Phone: (01772) 531343
Email: peter.iles@lancashire.gov.uk
Your ref: 3/2026/0356
Our ref: 3_2026_0356-LCC
Date: 19th June 2026

**Application 3/2026/0356: Erection of 77 no dwellings and creation of community parkland, with vehicular access from Whalley Road and associated infrastructure, parking and landscaping.
Land at Hammond Ground, Whalley Road, Read BB12 7RP**

Peter Iles
Planning Officer (Archaeology),
Historic Environment Team

MSSD2344 - Land at Hammond Ground, Read, Lancashire
 Figure 4 - Magnetic Interpretation
 1:2,000 @ A3
 © Magnitude Surveys 2026
 Contains Ordnance Survey data © Crown Copyright and
 database right 2026

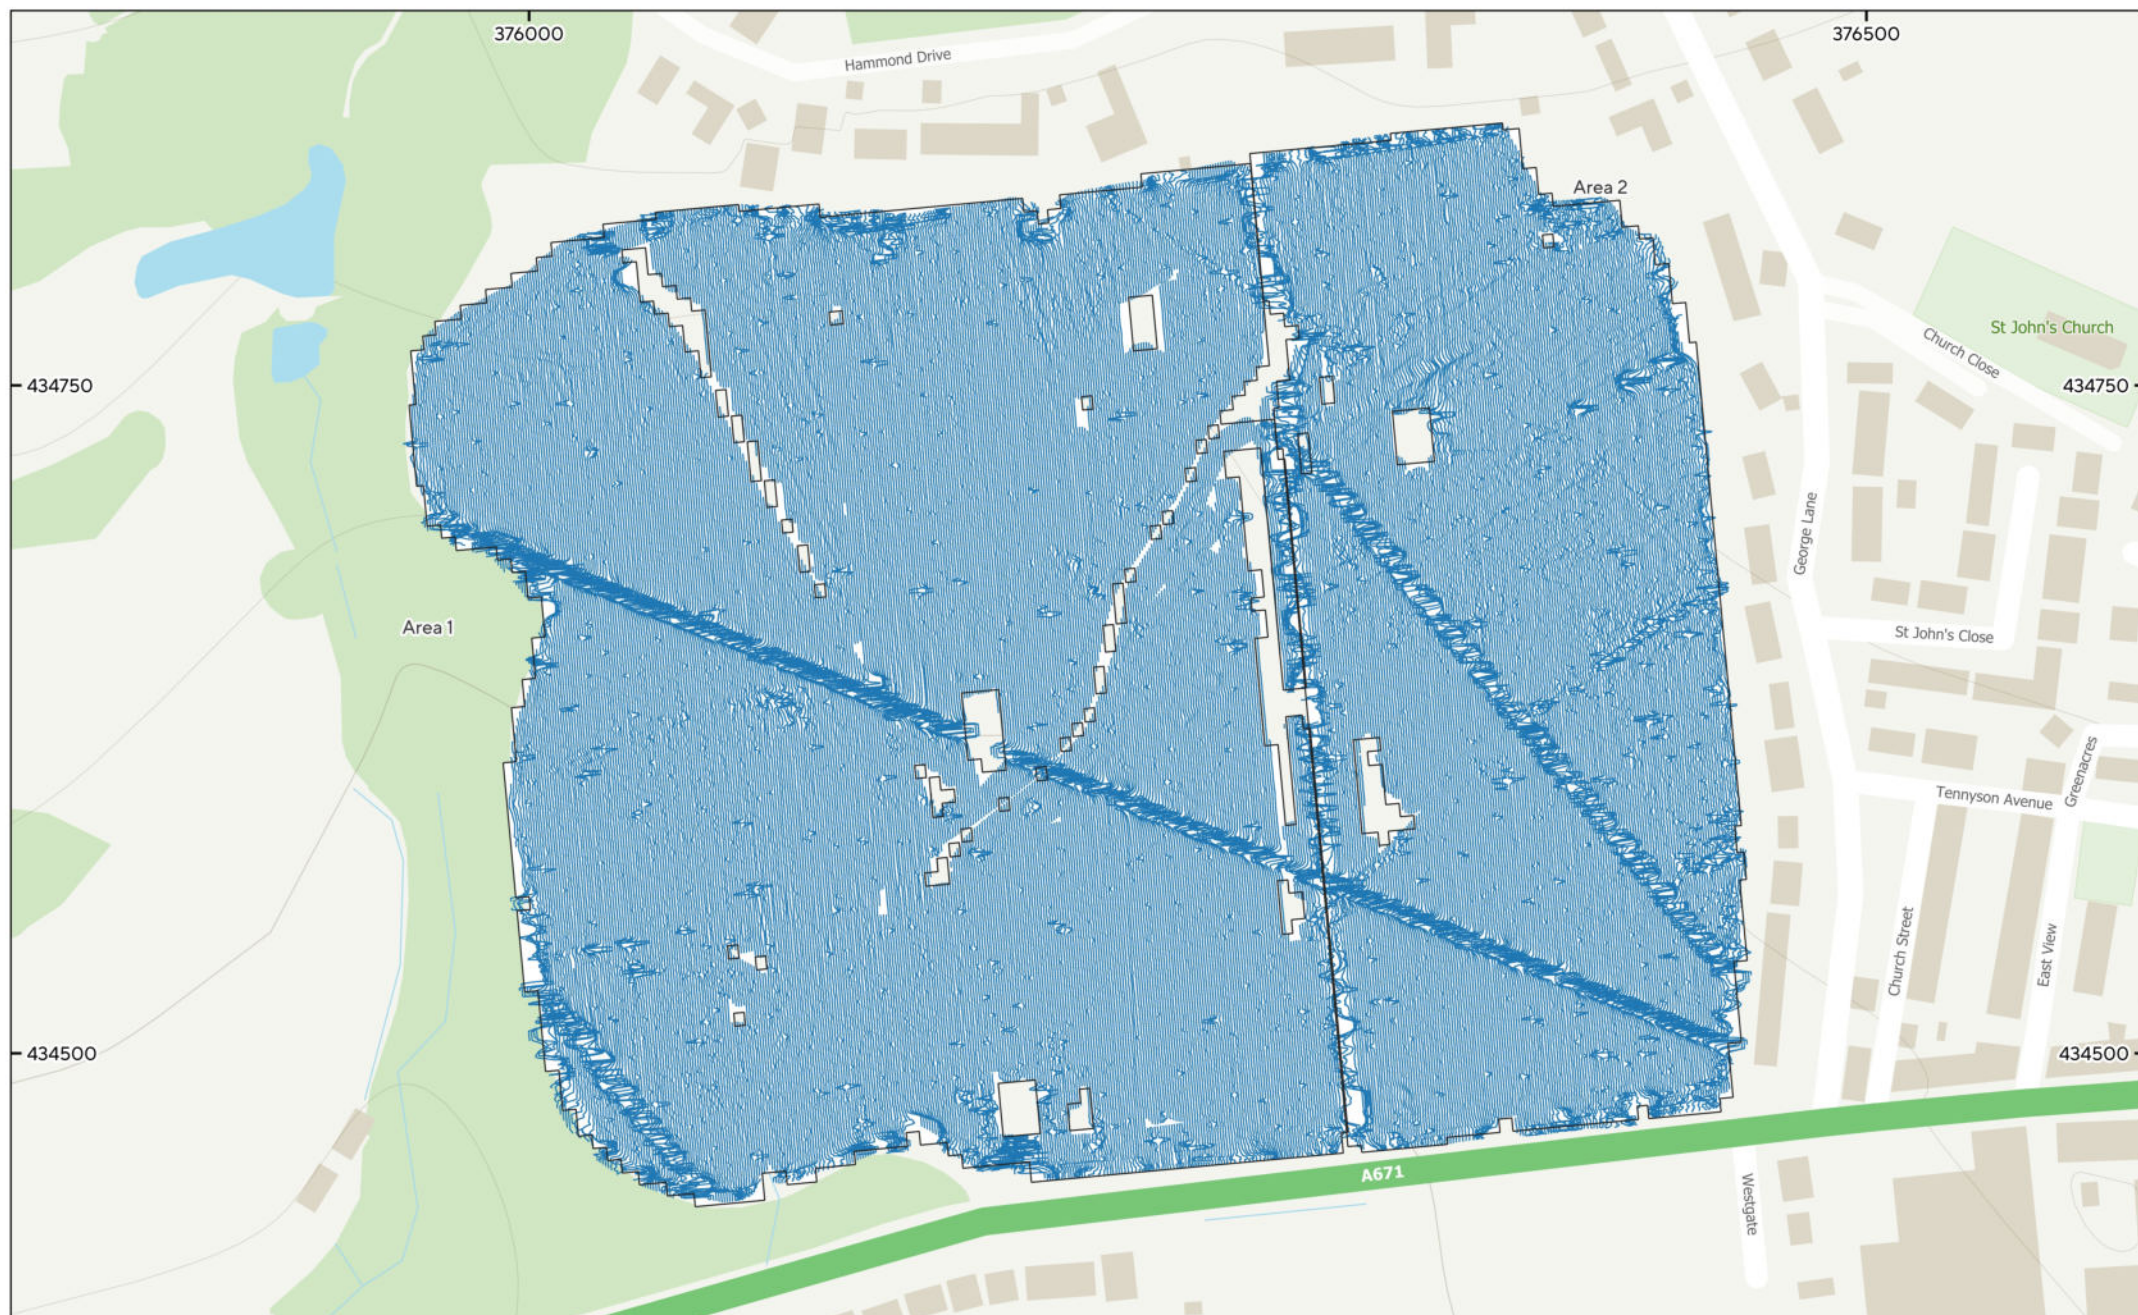
It is also noticeable that the lines of the water pipes identified on the sale plans do not align with the service pipe routes detected by the Geophysical Survey (GS Figs 3 and 4). This is probably the result of poor record-keeping but could also indicate new or

replacement pipework. The features noted in the northwest corner of the geophysical survey area do appear to have archaeological potential, although they could also relate to the landscaping of the park or natural processes. Remains of former field boundaries and other agricultural features probably pre-dating 1893 are seen on the GS and the LiDAR, as well as hinted at on the 19th century OS mapping, but there are also sufficient traces of other 'undetermined' features across the rest of the survey area to suggest that buried remains of earlier occupation will survive across the site. We would agree that the main threat to such remains is the proposed residential development on the east side of the site, but landscaping and other works (temporary or permanent) required elsewhere may also threaten them. Whilst they may be of early date (above), there does not seem to be sufficient reason to assume that they would be of sufficient importance to require preservation in situ at the expense of development. As such we would recommend that, should planning consent be granted for this or another development here, that a condition requiring a phased scheme of archaeological investigation is designed and undertaken prior to any ground disturbance occurring, is attached. The following wording is suggested:

Condition: No groundworks or other excavation, including preparatory works, stripping for site compounds, etc. or the installation of drainage or other services shall take place until the applicant, or their agent or successors in title, has secured the implementation of a phased programme of archaeological investigation, recording, and analysis. This must be carried out in accordance with a written scheme of investigation, which shall first have been submitted to and agreed in writing by the Local Planning Authority. All archaeological works shall be undertaken by an appropriately qualified and experienced professional archaeological contractor and comply with the standards and guidance set out by the Chartered Institute for Archaeologists (CIfA). The development shall be carried out in accordance with the agreed details.
